**From:** Jean Fraser  
**To:** Tom Greer  
**CC:** Jaegerman, Alex  
**Date:** 10/9/2013 6:15 PM  
**Subject:** 133 York Street- issues that need to be addressed urgently

Today we conducted the first substantive review of the recently submitted Hearing submissions on this project. It appears that there are several fundamental issues that need to be resolved prior to this being considered at a Public Hearing. We are not sure that these can be resolved (with reviewer signoffs) in time for the October 22, 2013 PB Hearing (for which the PB Report is finalized on 10.17.2013) and we strongly advise delaying the Hearing.

1 GROUND PLAN
Scale: 1/4" = 1'-0"

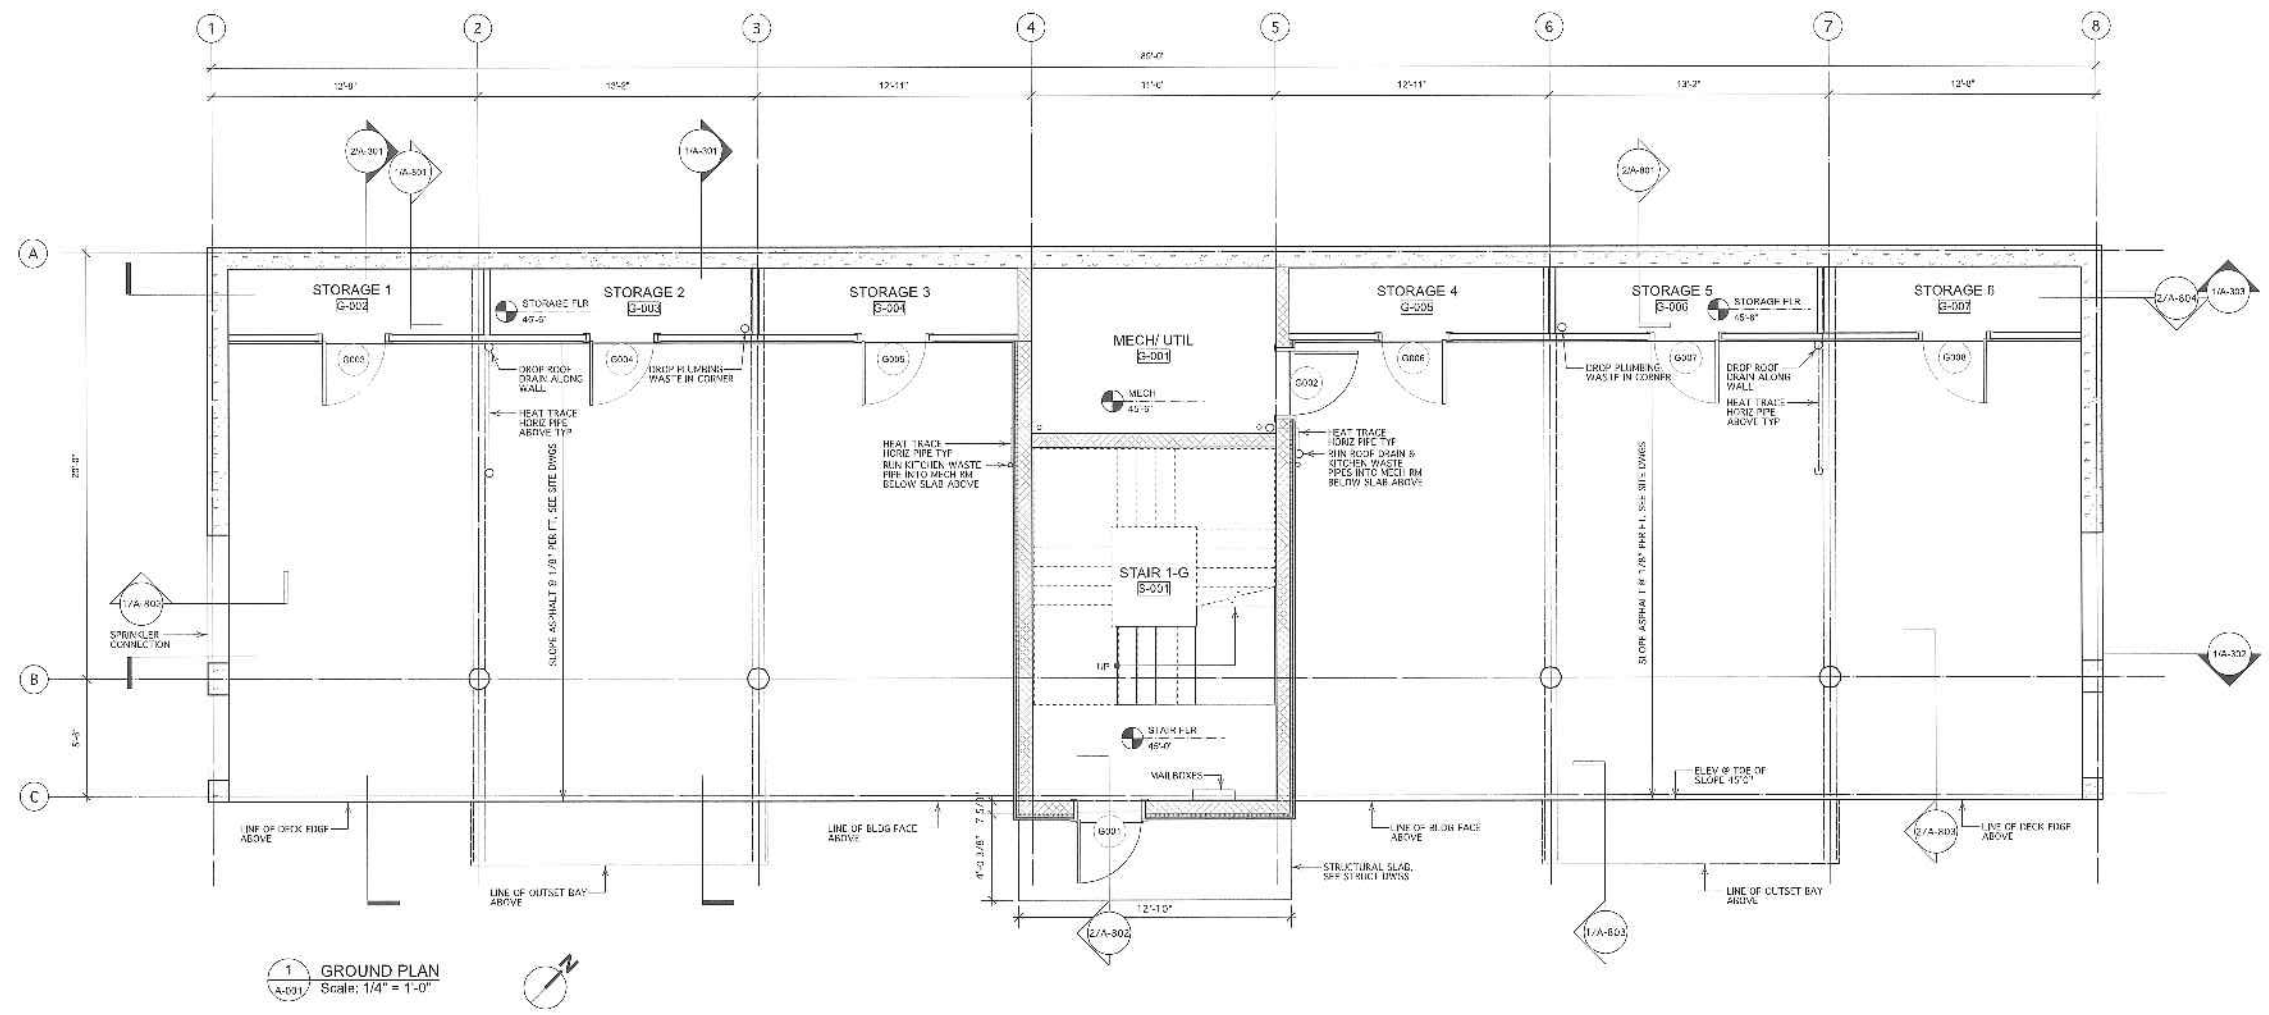
Based on the submitted site plan and recently received section, the available distance between the canopy and the new curb is about 10 feet; between the bays and the new curb is 12 feet and both appear to be lower than a fire truck. The entrance doorway to the building appears to be 15 feet from the curb. Also we are not sure whether fire apparatus can get around the corner (need to see template showing fire apparatus can get around the corner). Based on this it appears that the footprint of the building needs to be reconsidered.
